Email planning@uttlesford.gov.ukWebsite www.uttlesford.gov.uk**Application for a Non-Material Amendment Following a Grant of Planning Permission****Town and Country Planning Act 1990 (as amended)****Publication of applications on planning authority websites**

Conversion, extension and elevational alterations of the 3 no. adjoining barns to create 1 no. dwelling with associated development at Waters Farm Hammond Road Hatfield Broad Oak Essex CM22 7JS

UTT/22/1742/FUL

Title: As Proposed East/West Elevations  
 Client: Mr and Mrs Carter  
 Project: Essex Barn, CM22 7JS  
 Drawing No.: L(2-)-26 & 27  
 Scale: 1:50 @ A1  
 Date: March 2021

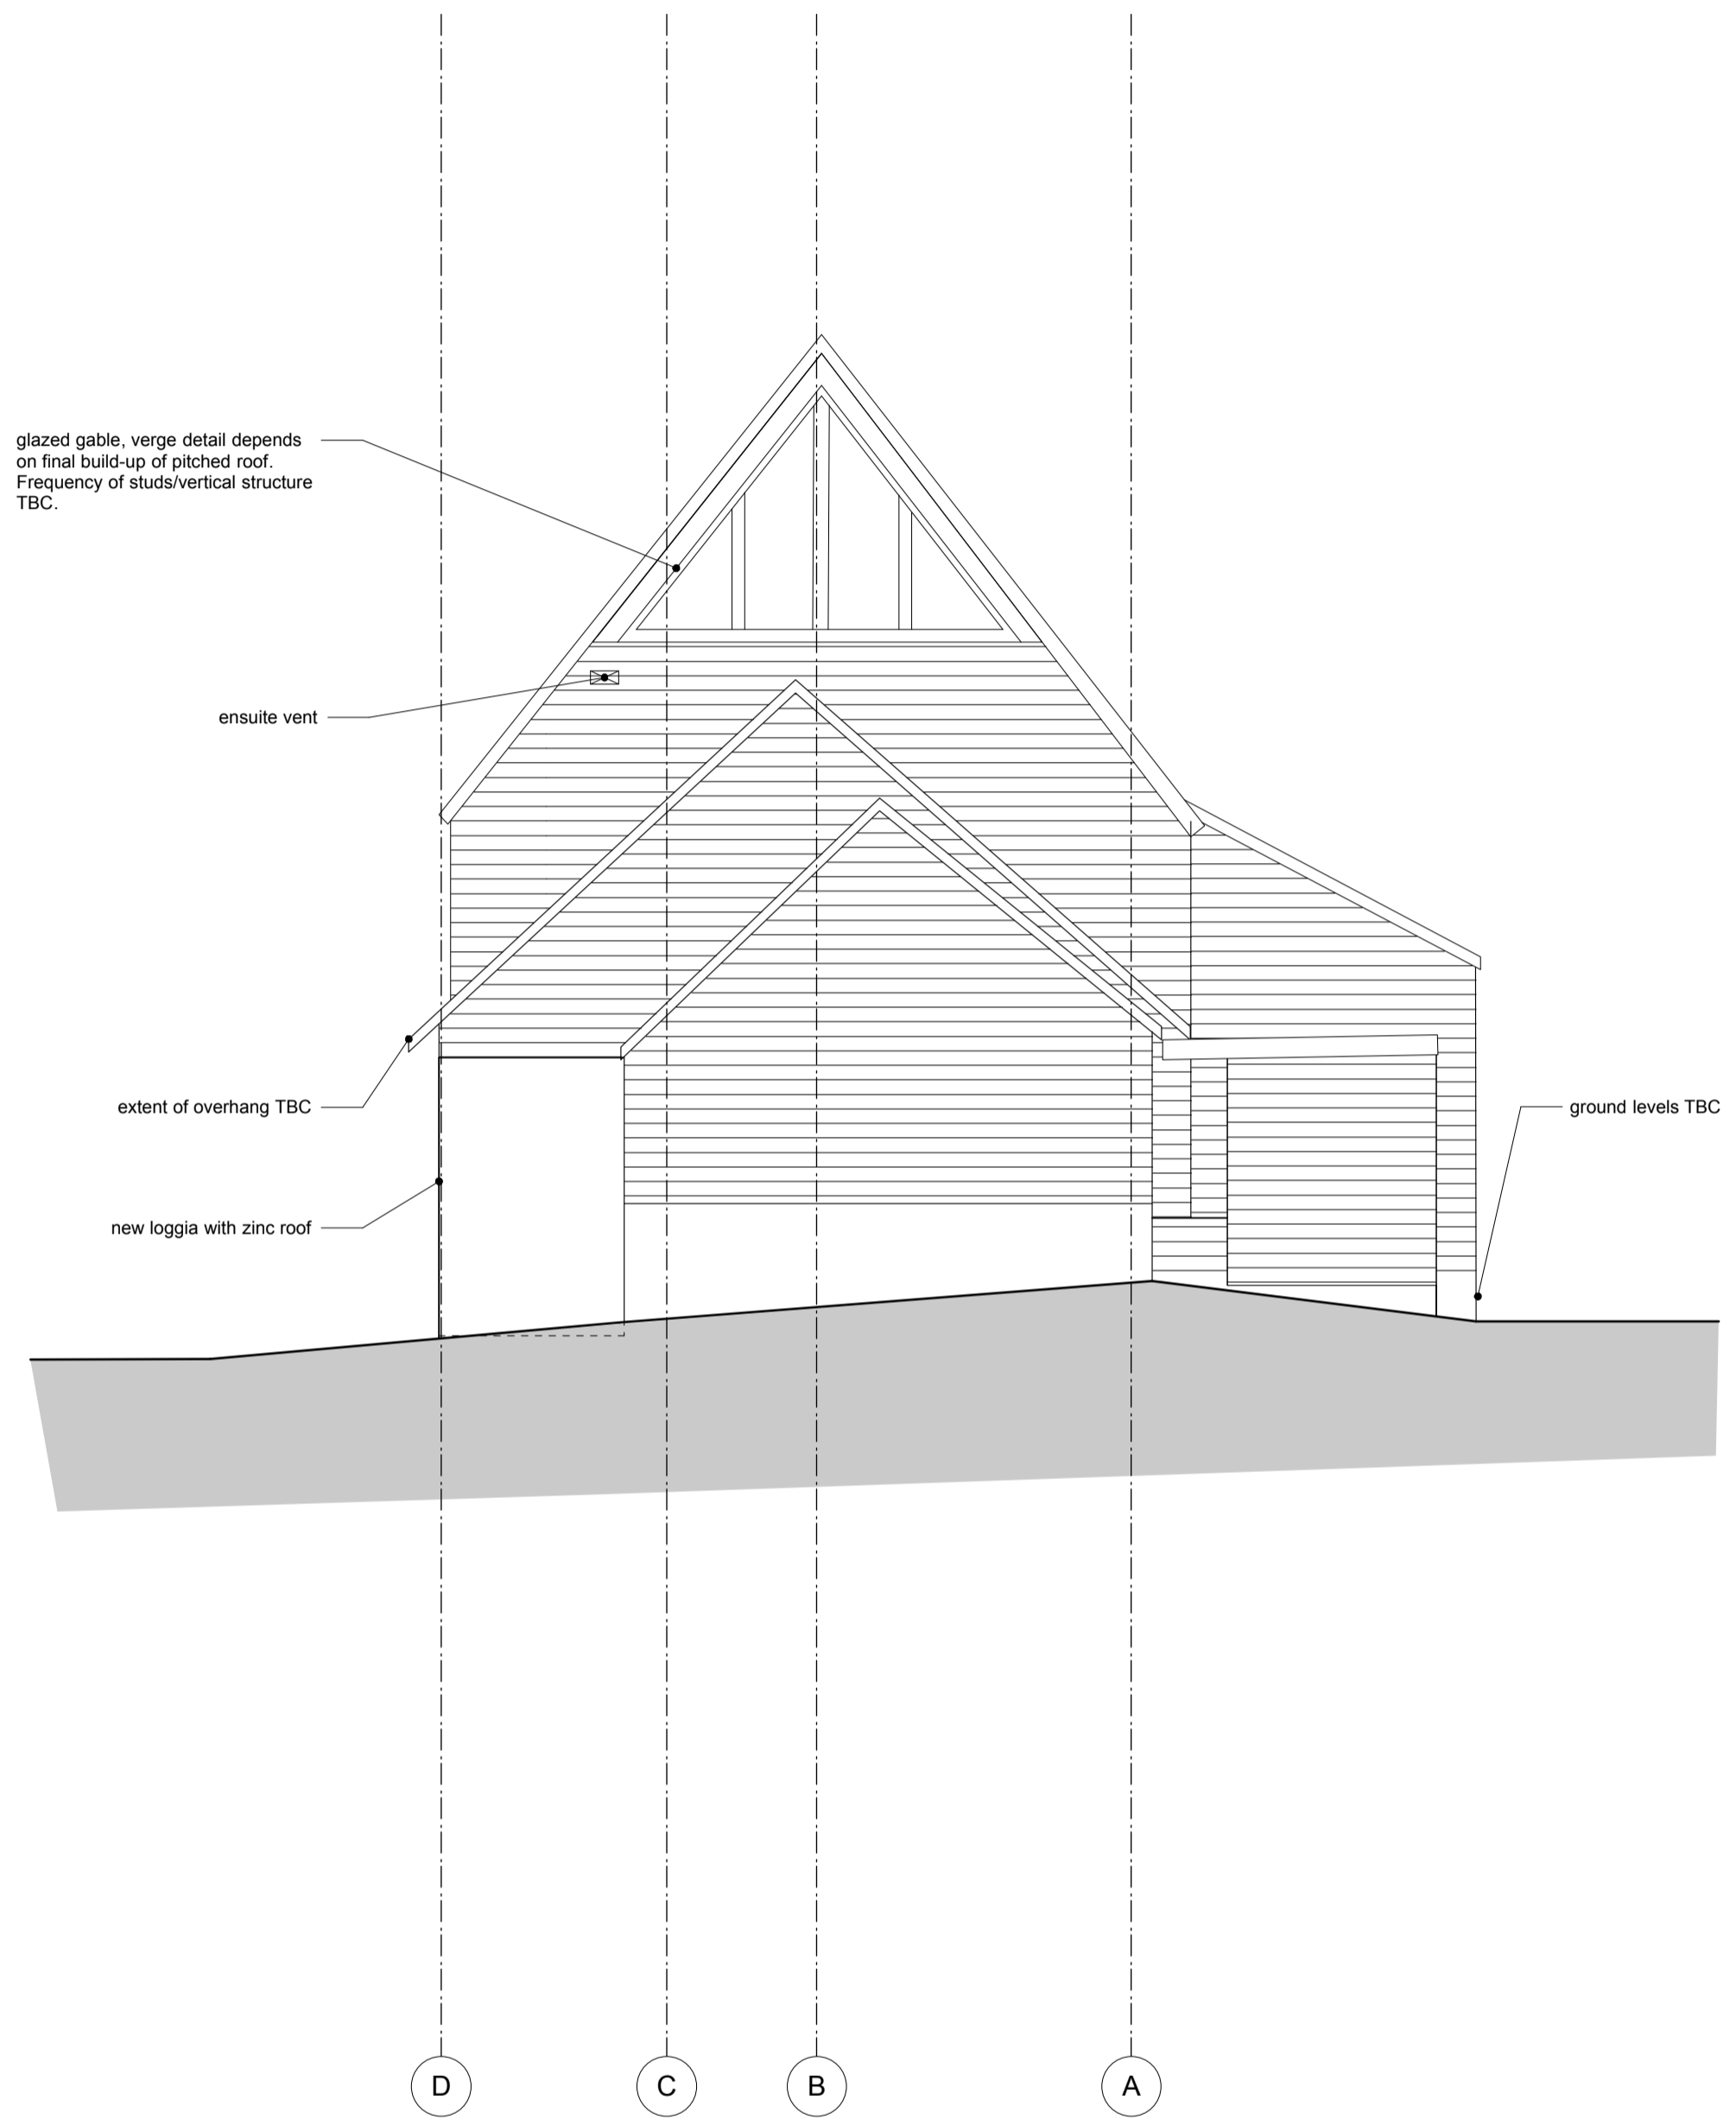
- South elevation: Remove one roof light, reposition one of the two remaining rooflights and reposition the window to the left of the front door.
- North elevation: Reposition two rooflights, remove one window in the loggia and reposition one of the two remaining windows in the loggia.
- East elevation: Remove one window and reposition the remaining window on the ground floor.

The proposed plans included in the original planning application were for a red brick plinth that would be partly rendered and a red brick wall to the loggia on the north elevation that would also be rendered. We wish to change this to a fully red brick plinth and wall i.e. there would be no render.
